Ribble Valley Borough Council
Housing & Development Control

Application no: **3/2021/1262**

Address: **Land at the North of the Chapel Hill site Longridge**

Proposal: **Full application for the erection of 4no. commercial units (Use Class E).**

Project  
**LAND AT CHAPEL HILL,  
 LONGBRIDGE, PRESTON, PR3 3BU**  
 PLANS & ELEVATIONS AS PROPOSED

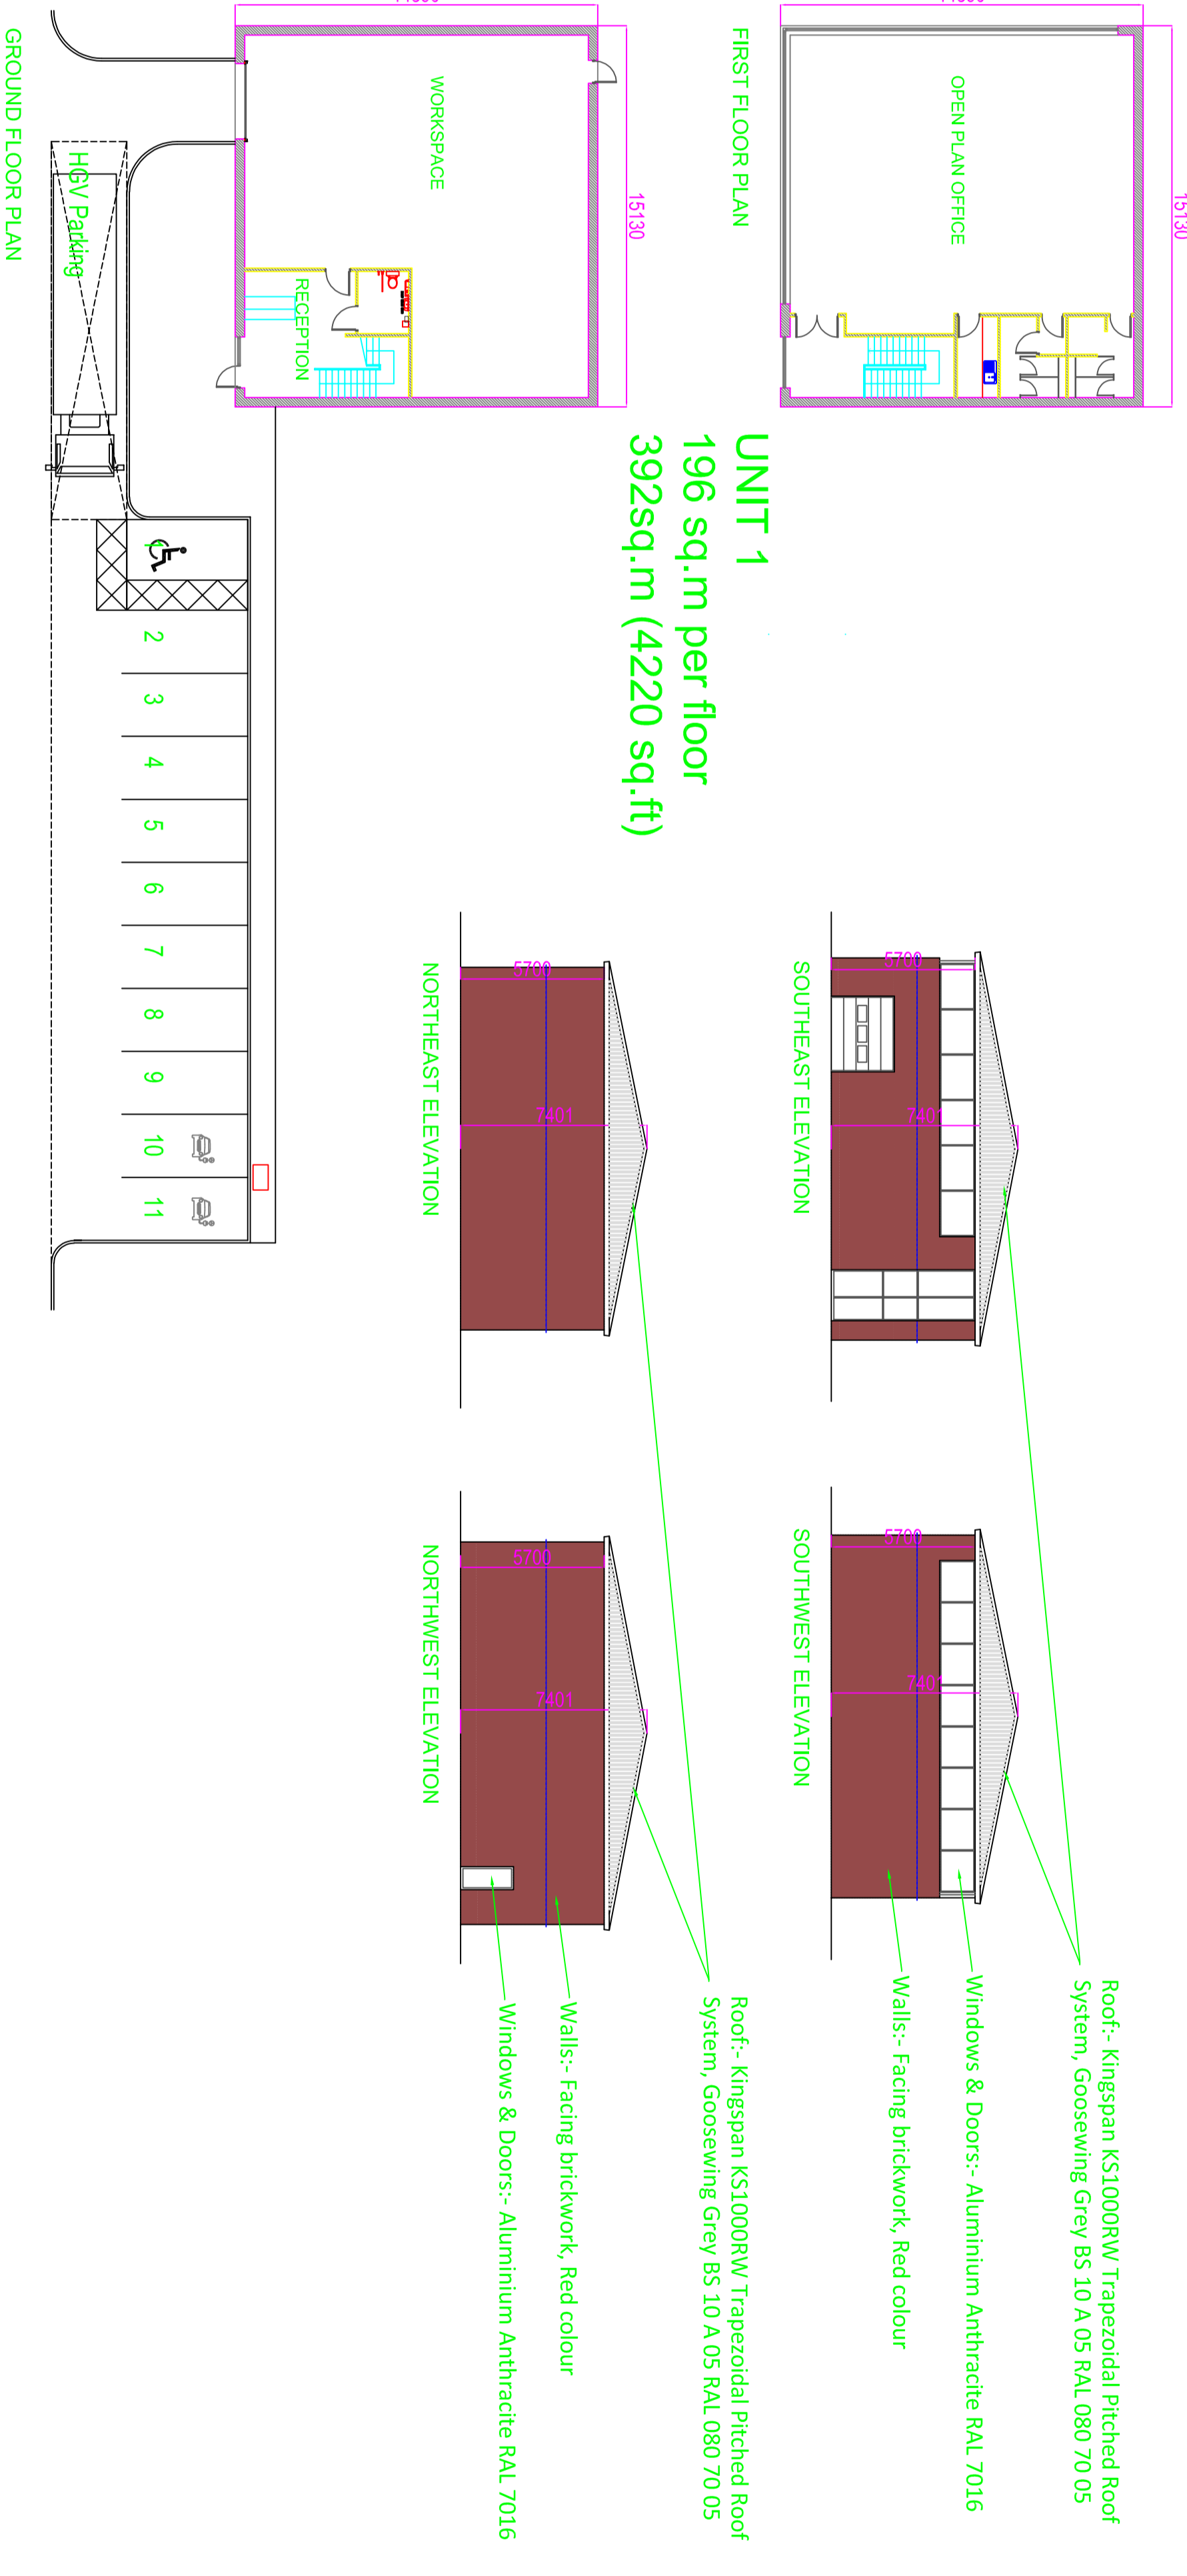
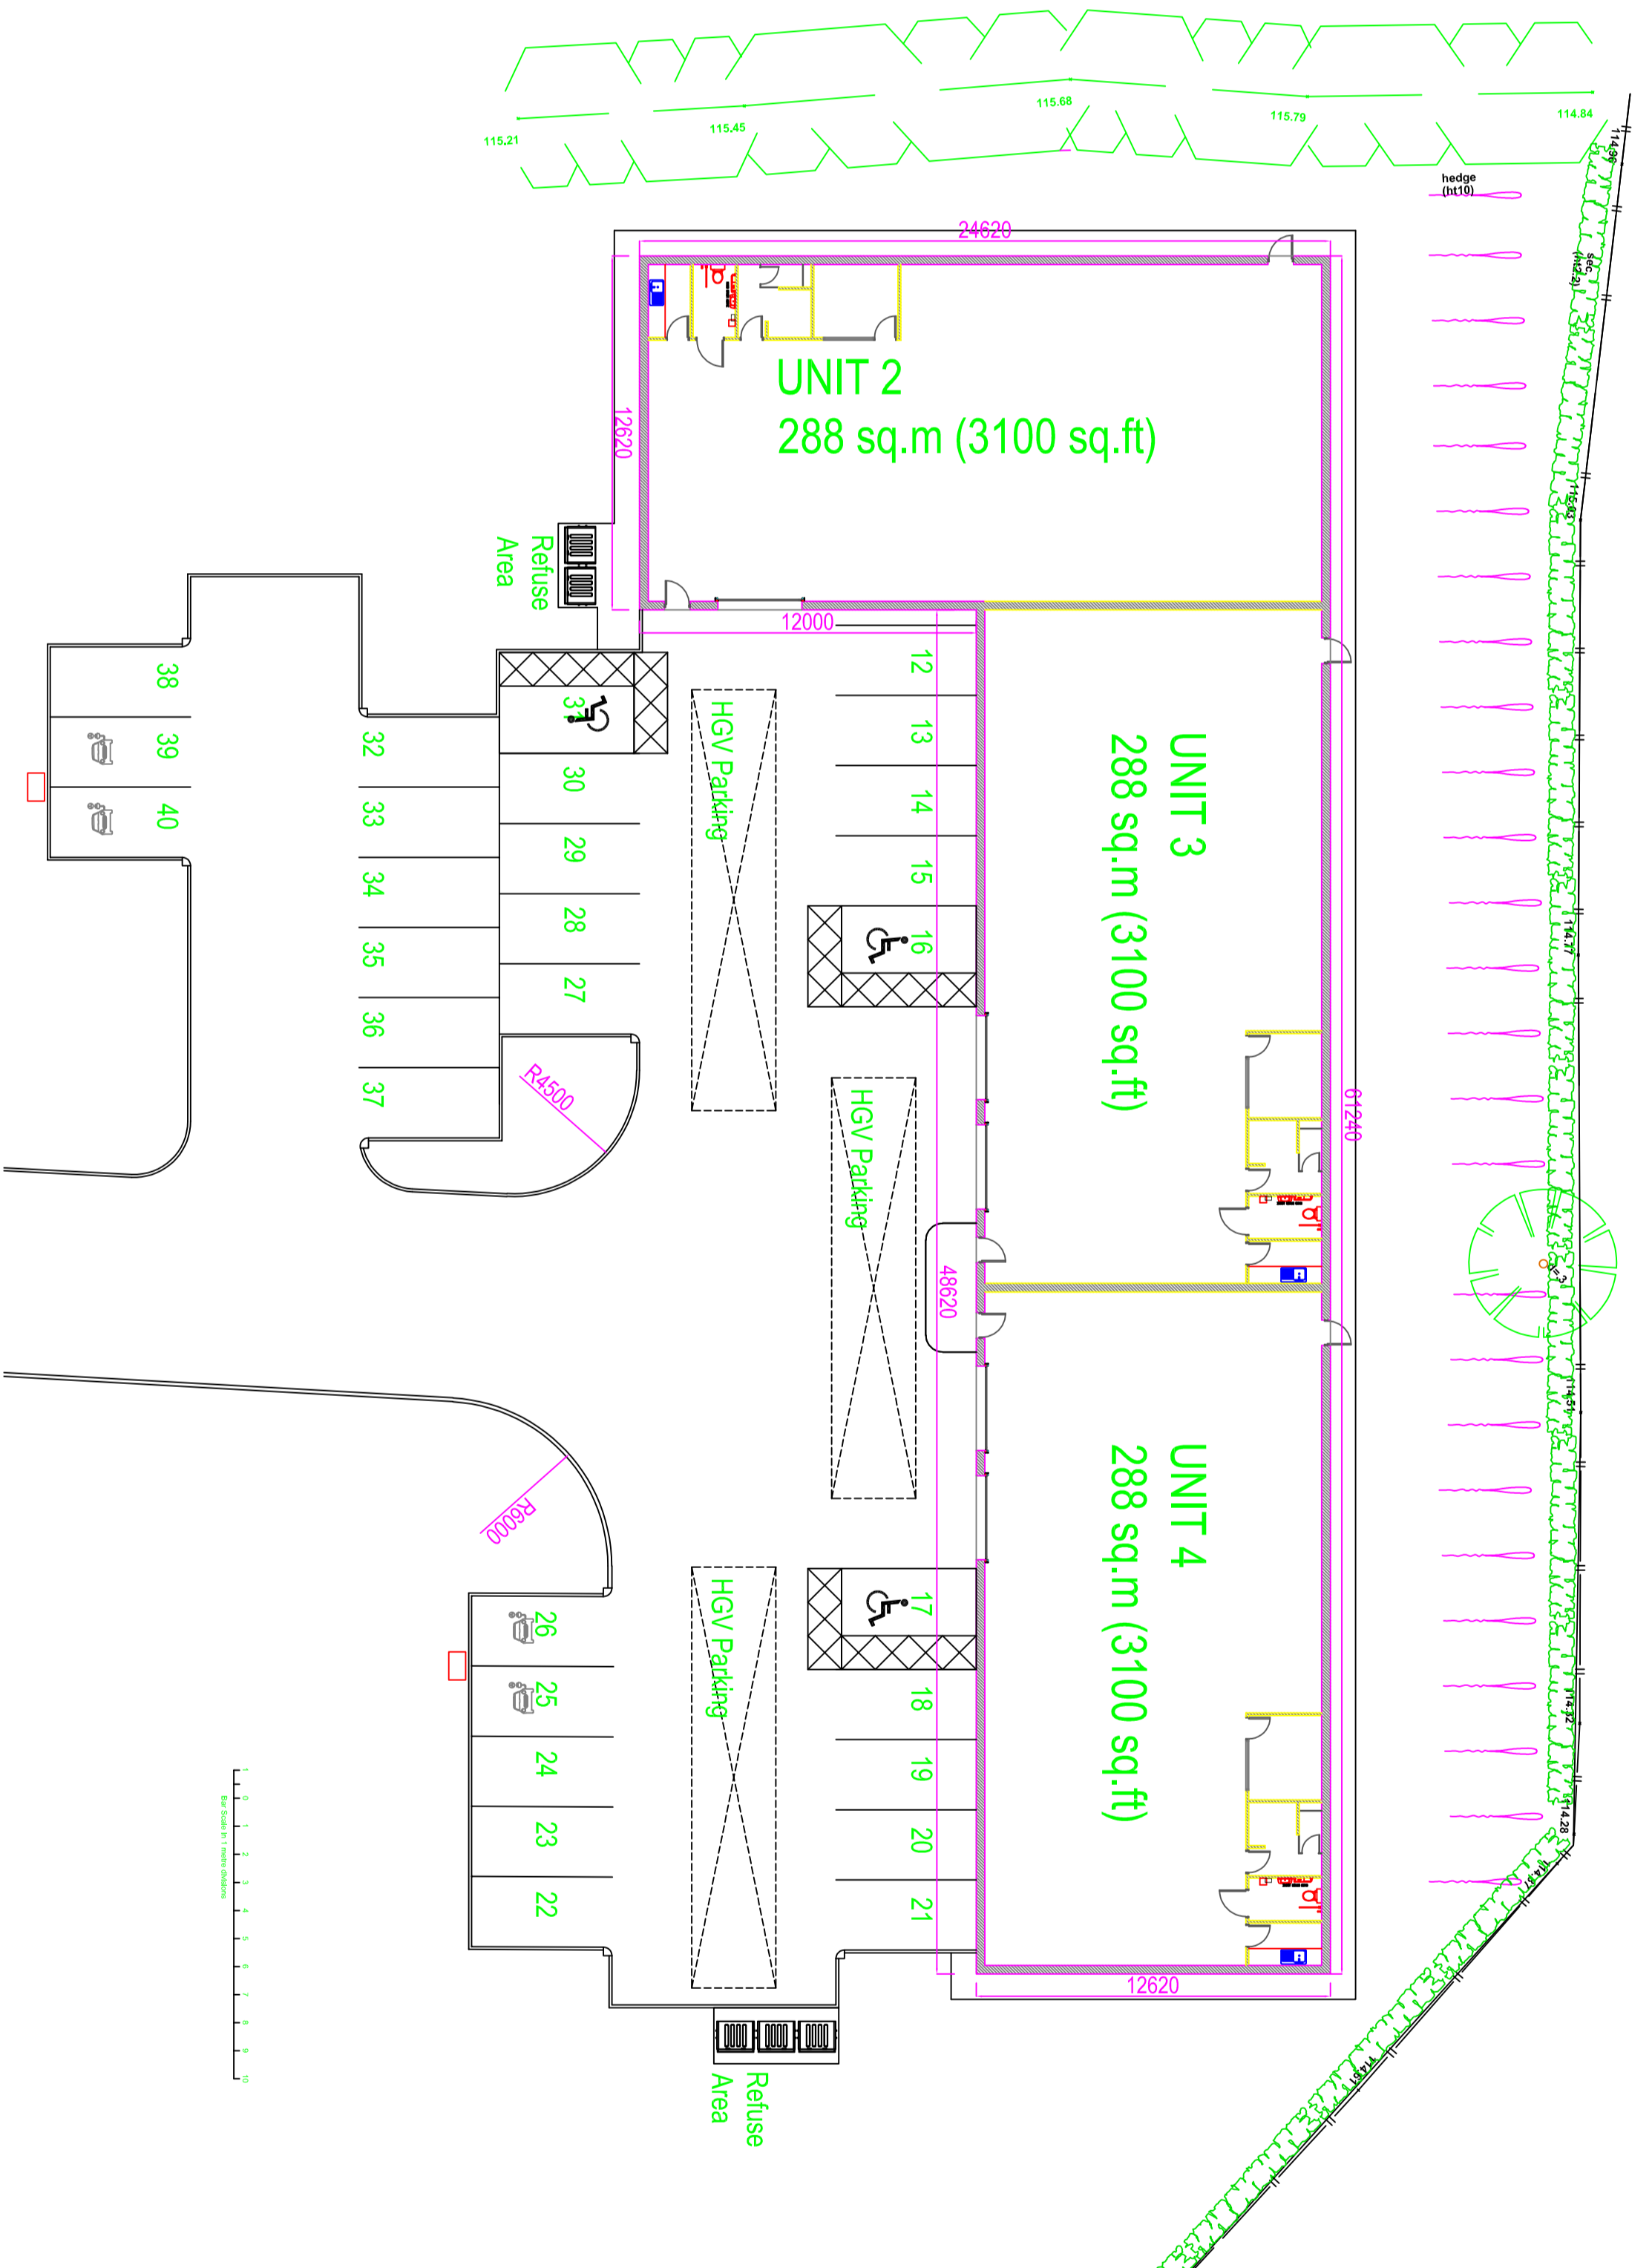
The LHA have reviewed IP drawing number 3 Rev C titled "Plans and Elevations As Proposed" and are aware that the site will provide 40 car parking spaces for the proposal. This complies with the parking standards found in the Joint Lancashire Structure Plan.

The LHA have reviewed the swept path analysis and have no objection to the use of the servicing areas apart from the area servicing Unit 4. This is because as shown on the swept path analysis, should a Heavy Goods Vehicle (HGV) be using the servicing area for Unit 2, for the HGV at Unit 4 to exit the site in a forward gear it would overlap car parking spaces 23 and 24, as well as car parking space 17. This could cause potential conflicts to occur should vehicles be parked in these spaces.

Therefore, as a result, the LHA require car parking spaces 22 to 26, to be setback further towards the red line boundary of the site to enable this movement to occur without conflict.

The amendment should be made on a revised plan and a revised swept path should be submitted showing that a reversing large vehicle will not conflict with the car parking spaces.
